Subject: IOZ Design Review – 222 St. John Street (Maine Medical)
Written by: Caitlin Cameron, Urban Designer
Date of Review: Monday, August 27, 2018

The proposed garage at 222 St. John Street for the Maine Medical Campus was reviewed for the Planning Board workshop by Caitlin Cameron, Urban Designer, Nell Donaldson, Senior Planner, and Deb Andrews, Historic Preservation Program Manager. This project was reviewed according to the adopted IOZ IDP and Regulatory Framework standards.

ROOF DECK PARKING LIGHTING STATISTICS:

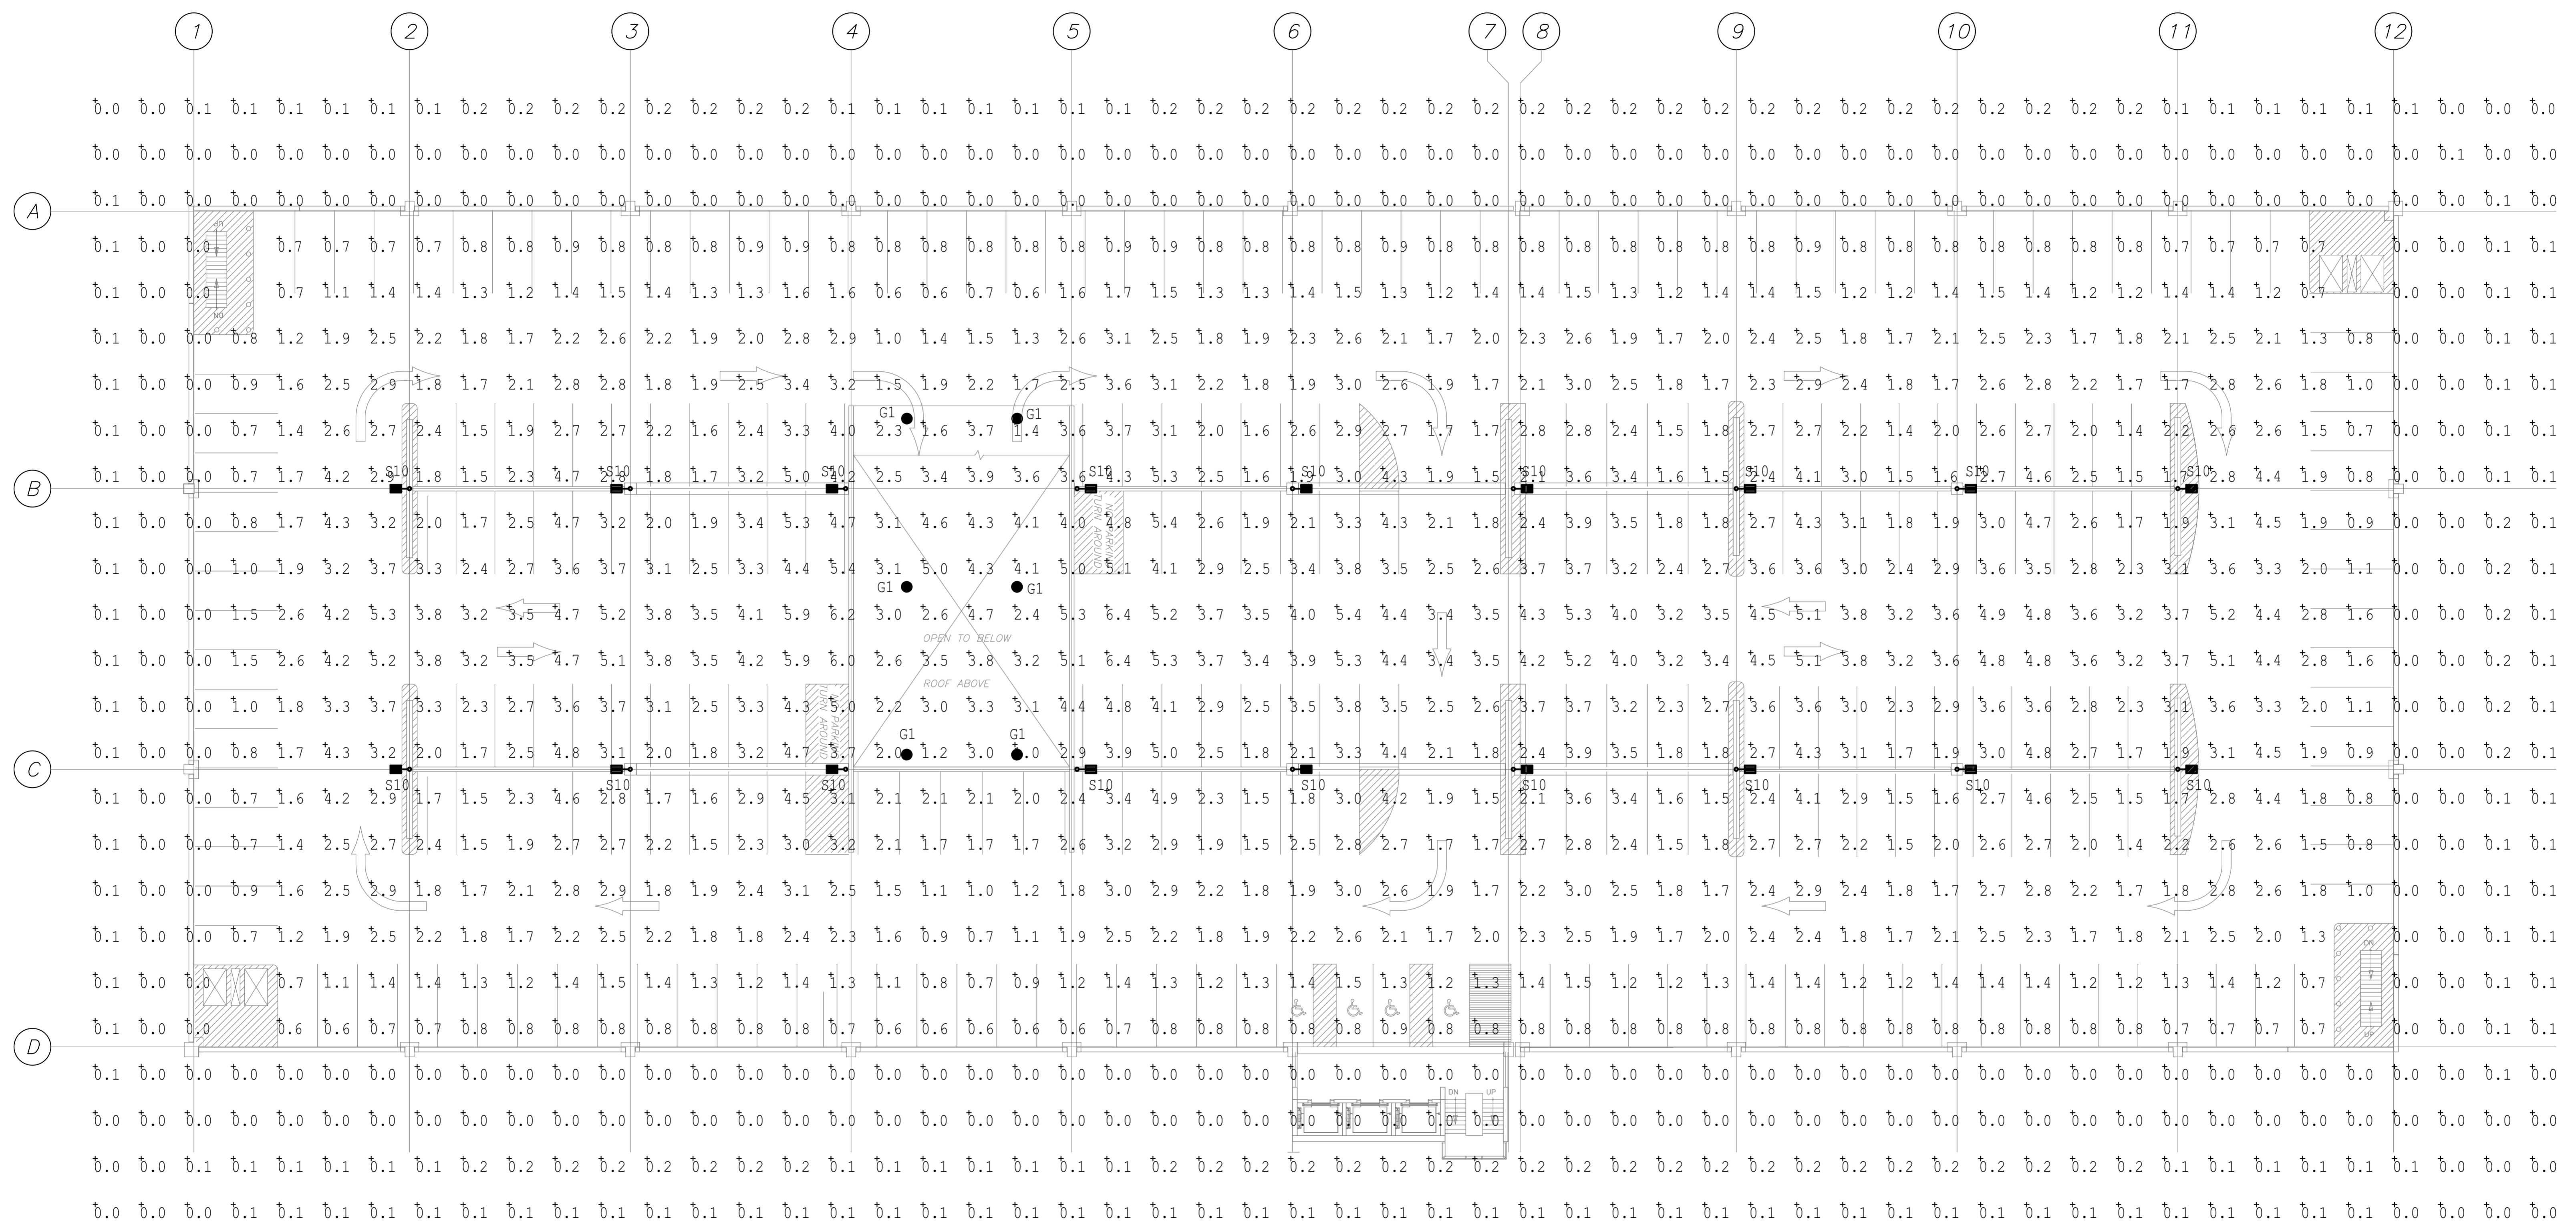
- **Are the ramp and circulation tower roofs adequately depicted in the renderings?** It is difficult to tell how visible these will be with the materials provided.
- **Concern about the visibility of the roof lighting poles and light levels, especially the impact on the Western Promenade.**
- The roofs at the top level are proposed to be glass to mitigate their visibility.

- **Clarify whether there is building lighting above the ground level – No lighting on upper stories except the poles on roof level.**
- **Concern about light trespass** on neighboring residential properties and level of light visible from the Western Promenade at night. **More information is requested regarding the impact of site lighting from the long views, especially light trespass and visibility of the lighting on the upper stories and roof from the Western Promenade. – Applicant provided rendering to convey the level of light and glare from the roof level.**

Updated Comments: The applicant confirmed the rooftop appurtenances are depicted in the renderings. The nighttime rendering shows the impact of the lighting at night from the Western Promenade – the ideal condition is for no lighting at this rooftop level. The applicant responded by placing all the poles as far away from the building edge as possible, selecting fixtures that will not spread glare outwards, and the roof will not be open for parking at night if not needed. Staff are satisfied with this aspect of the project.
